A | 419 King Street
Newtown NSW 2042
P | 02 9168 9893
E | admin@wmseng.com.au
W | wmseng.com.au
ABN | 85 700 247 836
Ref | 20345-L01-2
Date | 16 January 2026

24-28 Middle Harbour Road, Lindfield – Response to NSW SES Feedback

The Proponent has received feedback from the NSW State Emergency Service (SES) following the submission of the Flood Impact and Risk Assessment (FIRA) as part of the EIS submission for the SSD (SSD-82548708). The responses are identified below and references are provided to show where they are addressed in the updated report.

Post-Development
Peak Flood Hazard Afflux
0.5% AEP

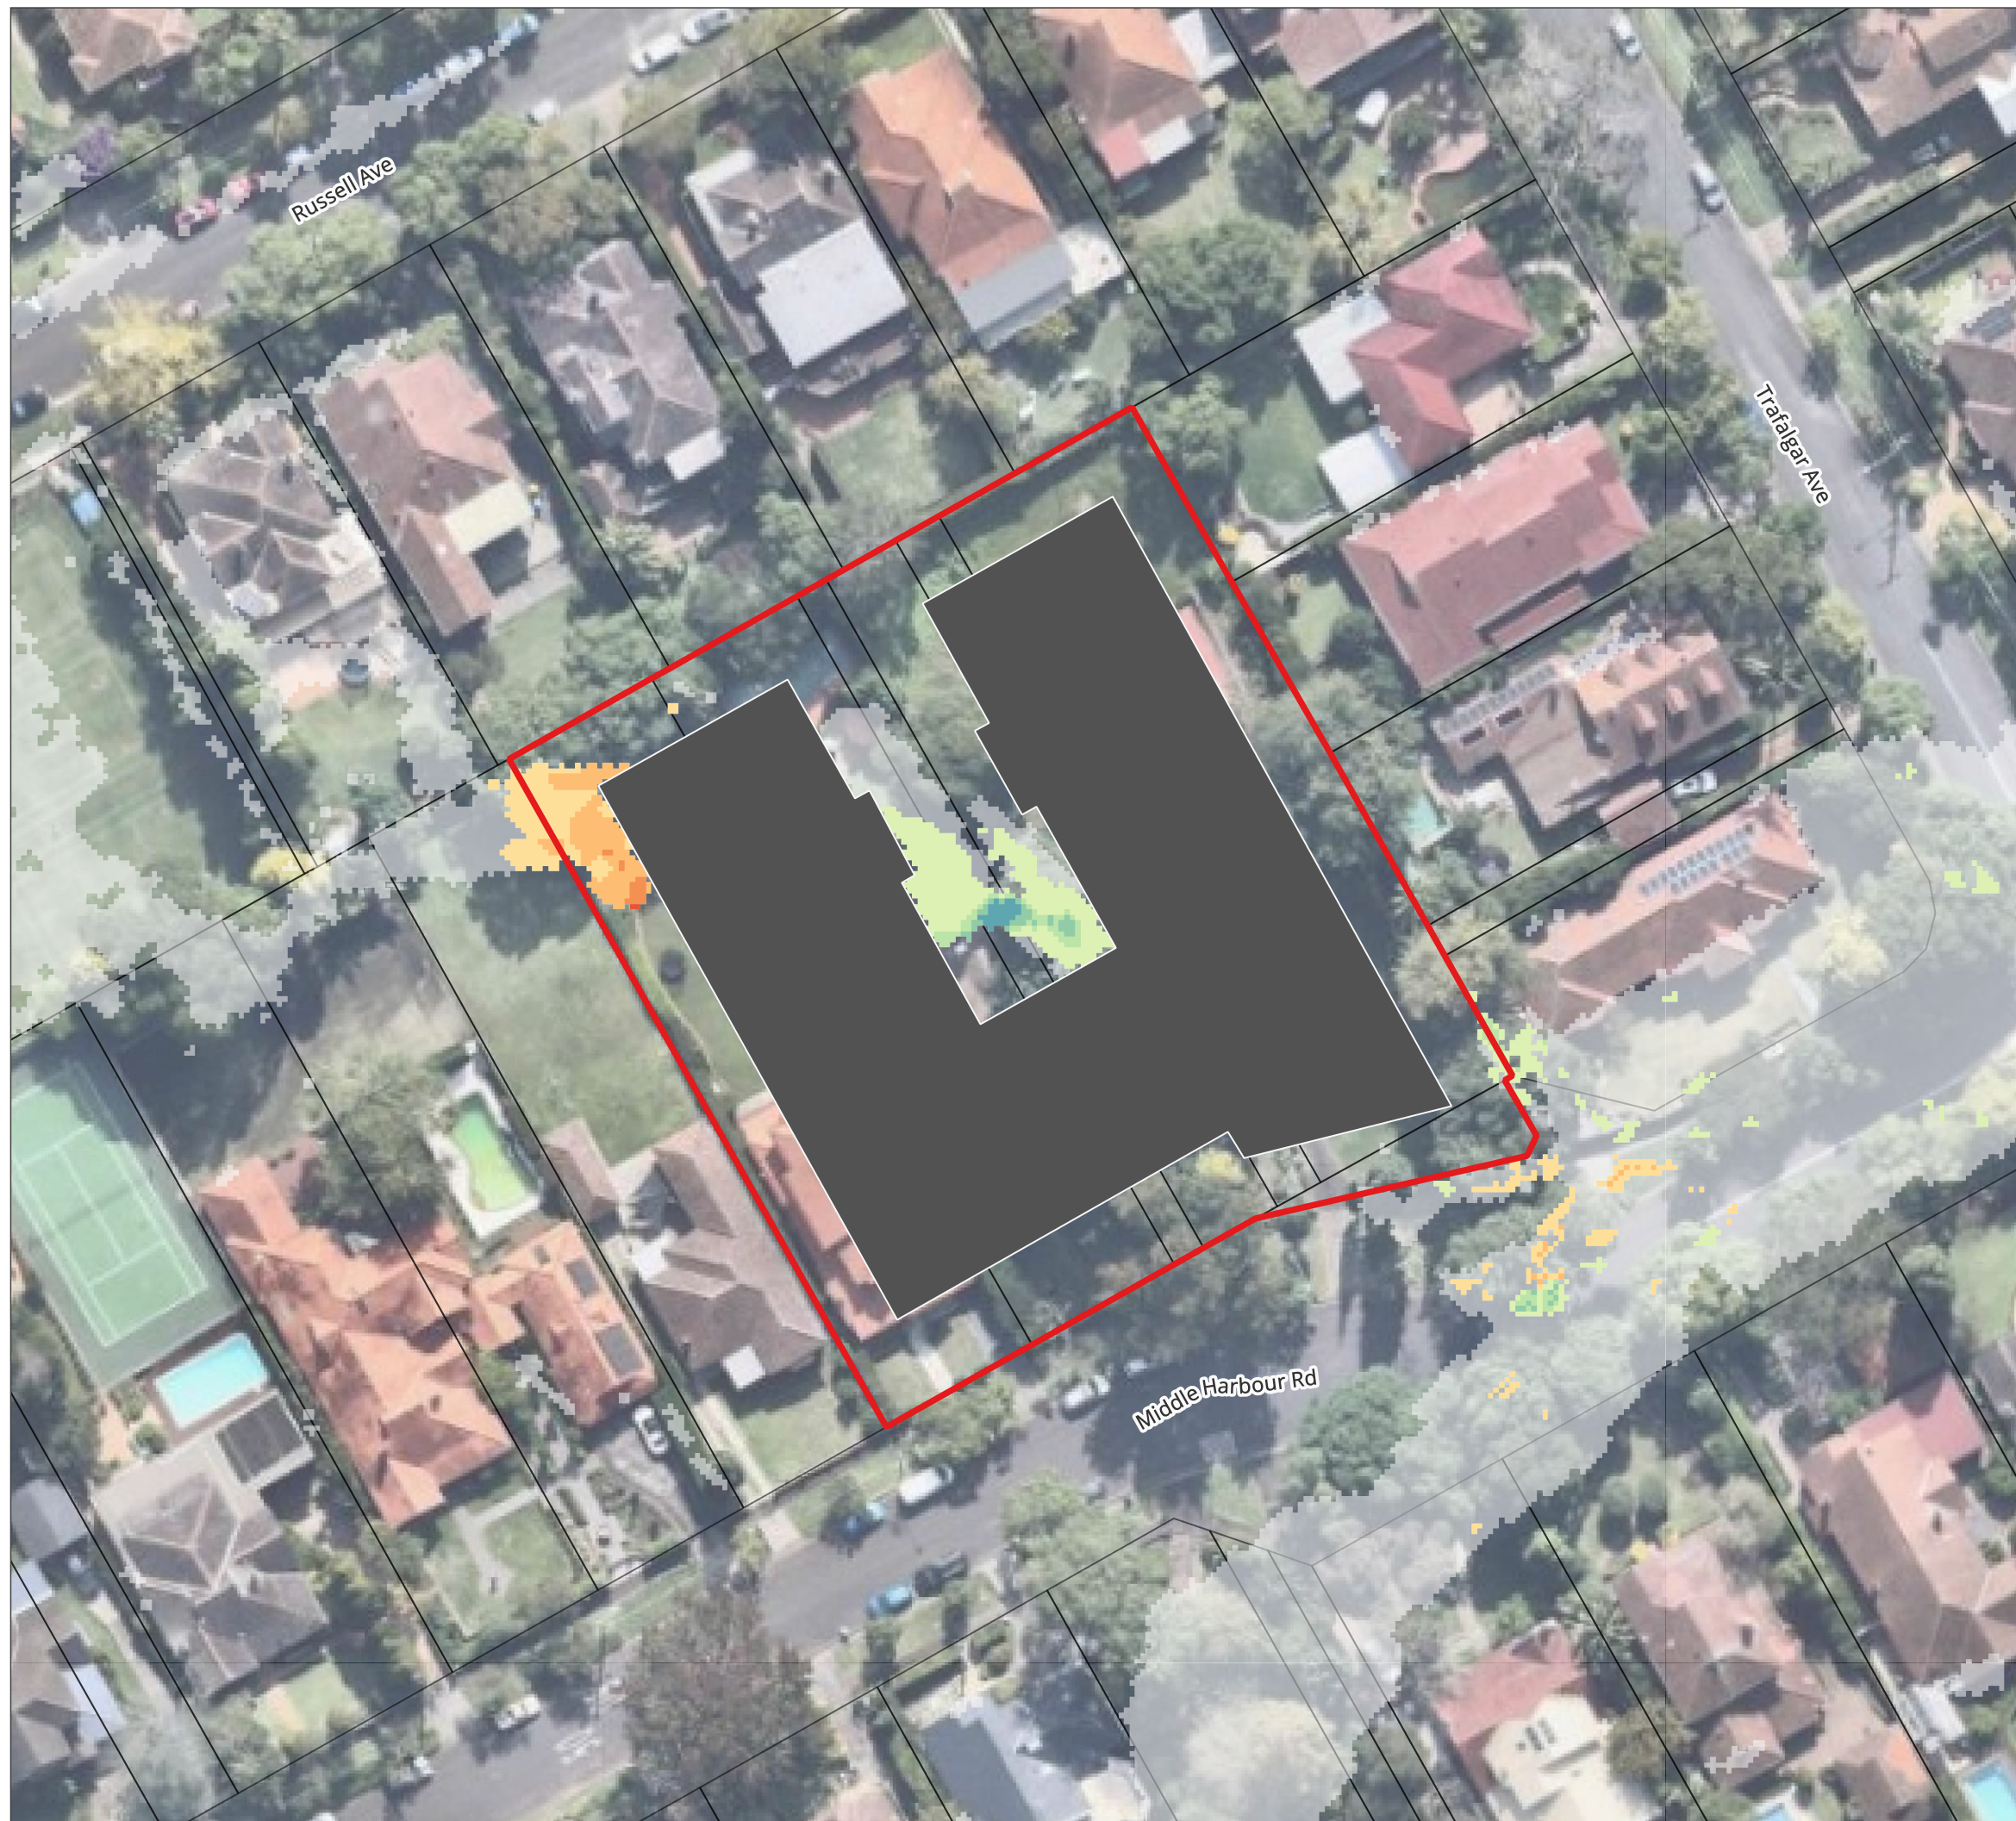
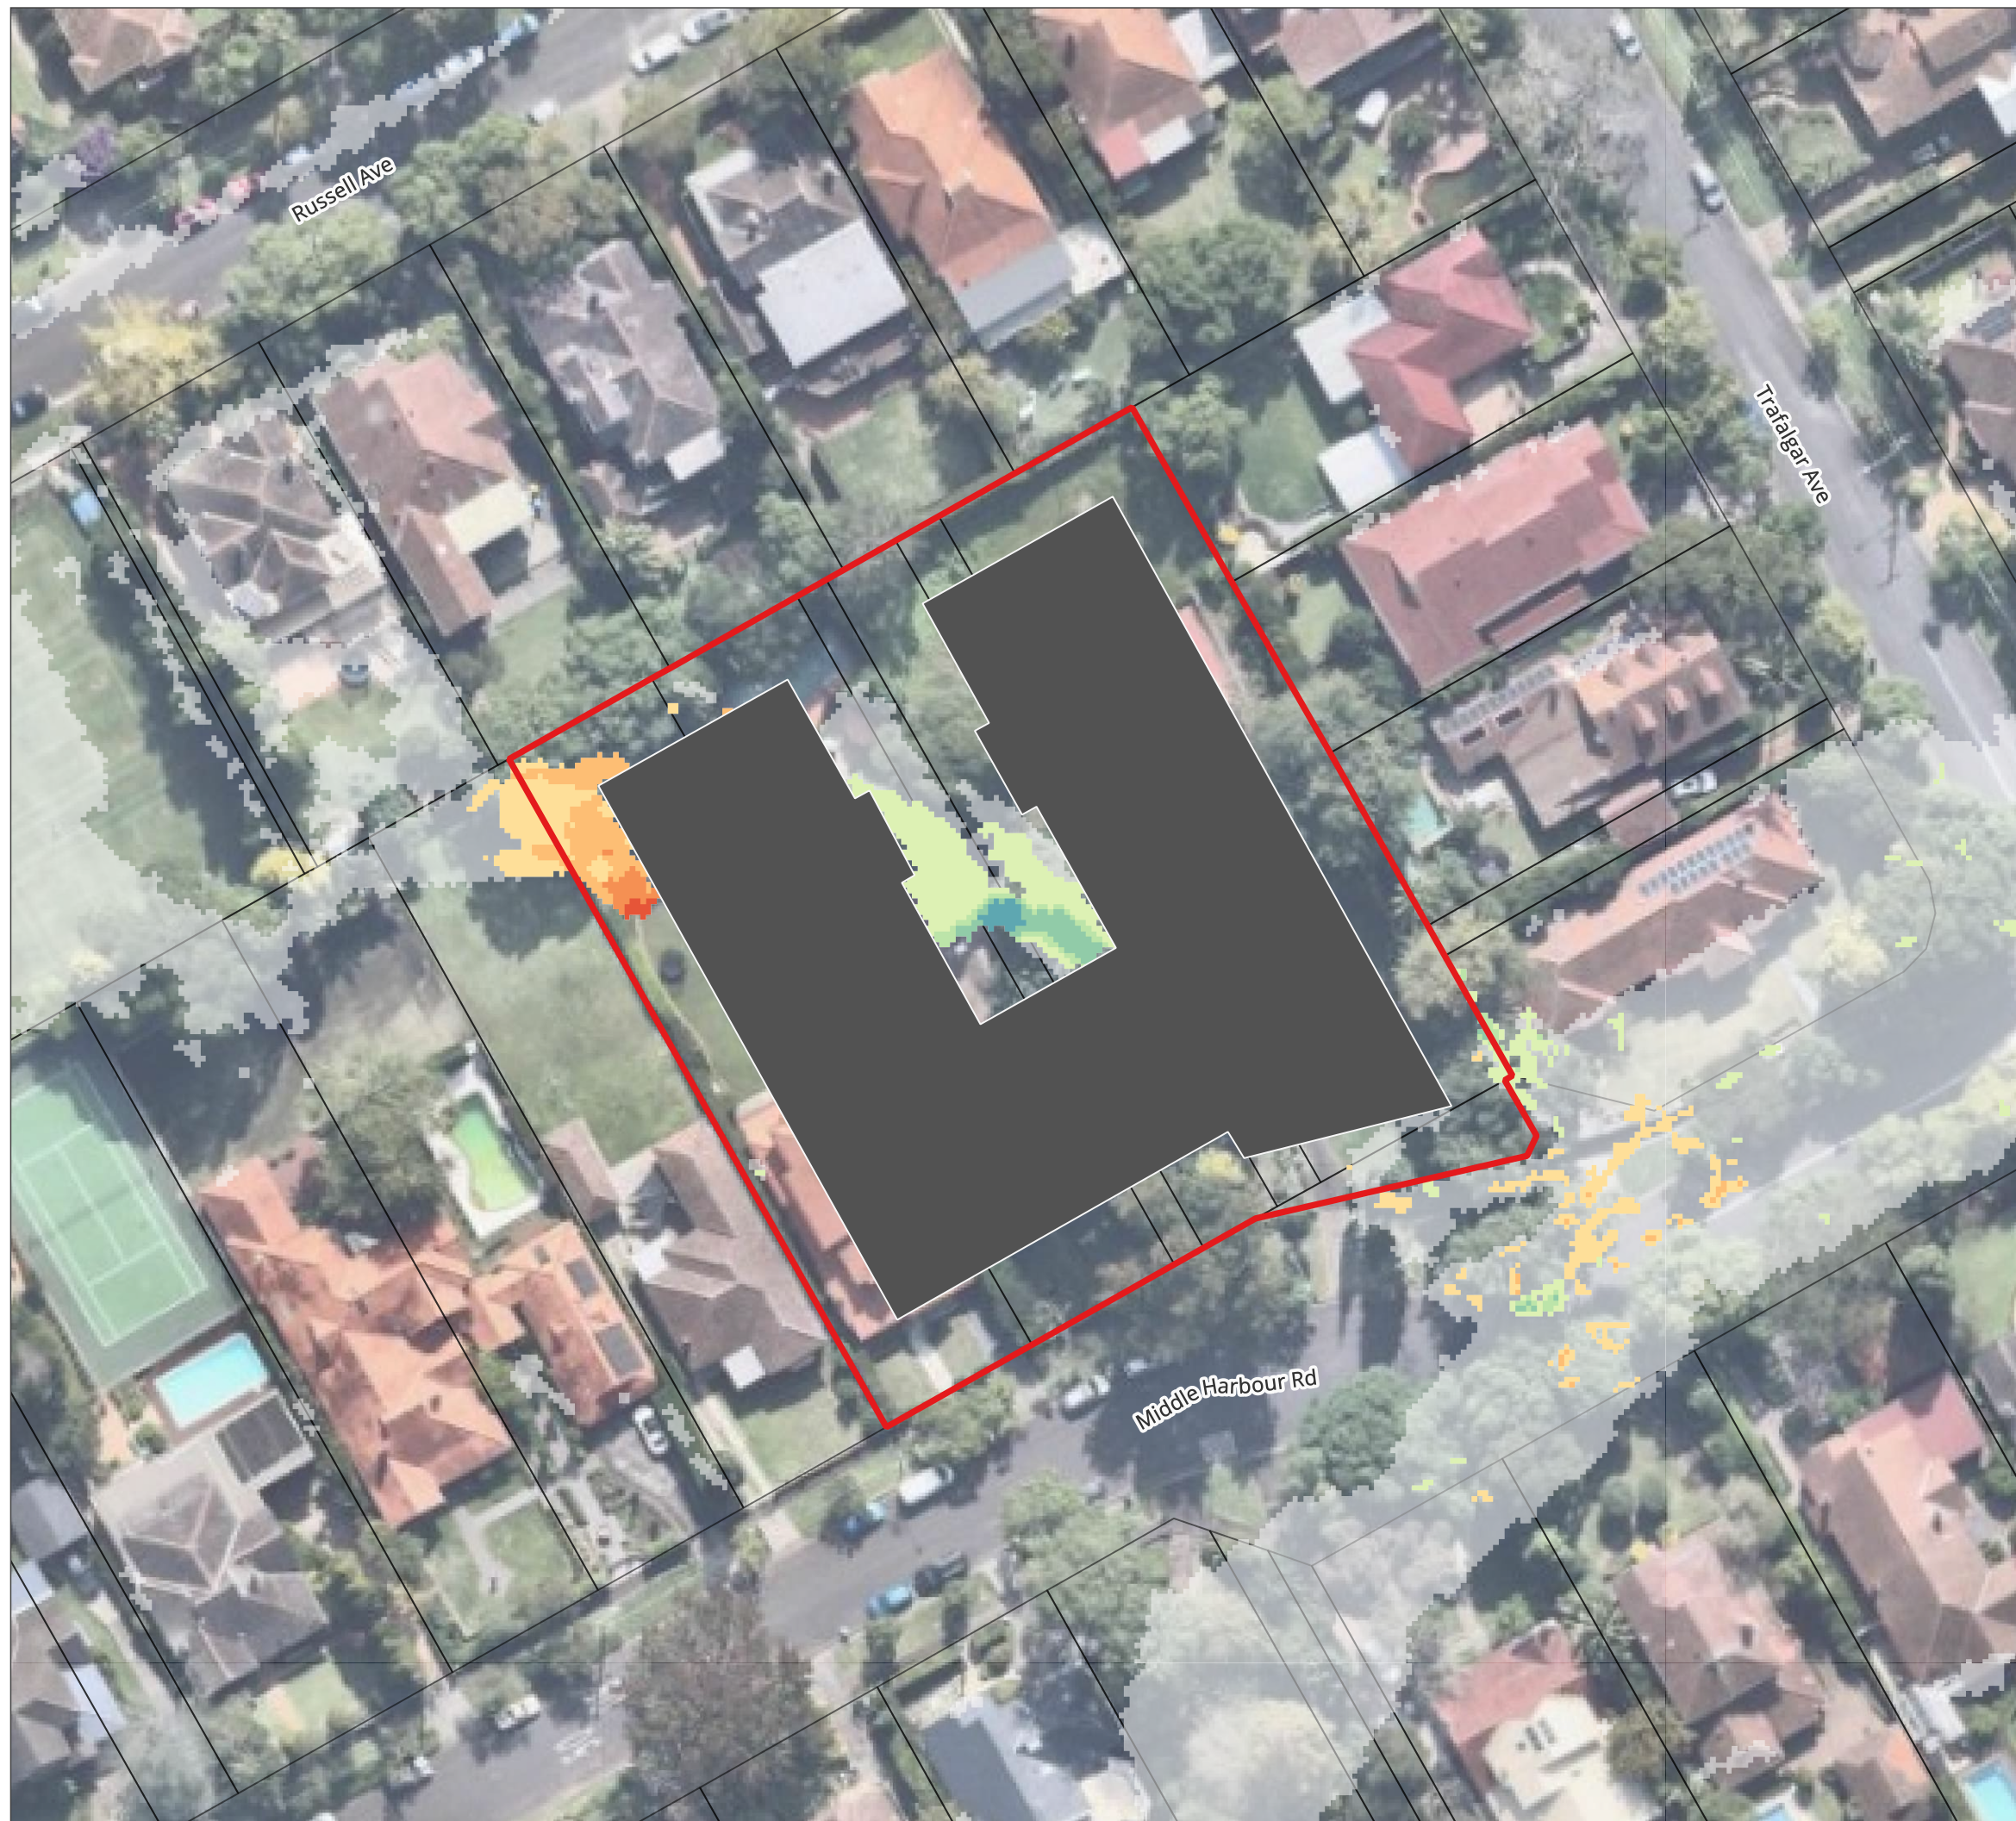
Current evidence suggests that flood events will become more frequent due to climate change. Flood impacts and risks due to climate change should be considered, beyond providing modelling for these events. The afflux models for the 0.5% AEP and 0.2% AEP (proxies for the 1% AEP event plus climate change) clearly demonstrate increases in the area inundated by floodwater under both scenarios, with flood depths adjacent to the site increasing by up to 0.30m during an 0.5% AEP event and greater than 0.30m during an 0.2% AEP event. These afflux levels are not insignificant. The climate change proxy modelling also shows that climate change would increase flood hazard by 1-2 levels in various locations adjacent to and downstream from the site.

The climate change assessment undertaken in the FIRA shows flood level increases of up to 0.3 m are expected across most of the site, except within localised areas within the swales where increases of up to 0.45 m are observed in the 0.2% AEP event. The development finished floor level has been set to over 1 m higher than the applicable 1% AEP flood level at the entrance, and all surrounding balconies are protected by solid walls set to 0.3 m above the applicable 1% AEP flood level. Similarly, the driveway entrance crest is 0.3 m above the applicable 1% AEP flood level. While it is not feasible to adopt crest levels consistent with the rarer climate-change-adjusted events due to geometric and operational limitations, the selected design levels aim to balance flood resilience with the physical constraints of the site.
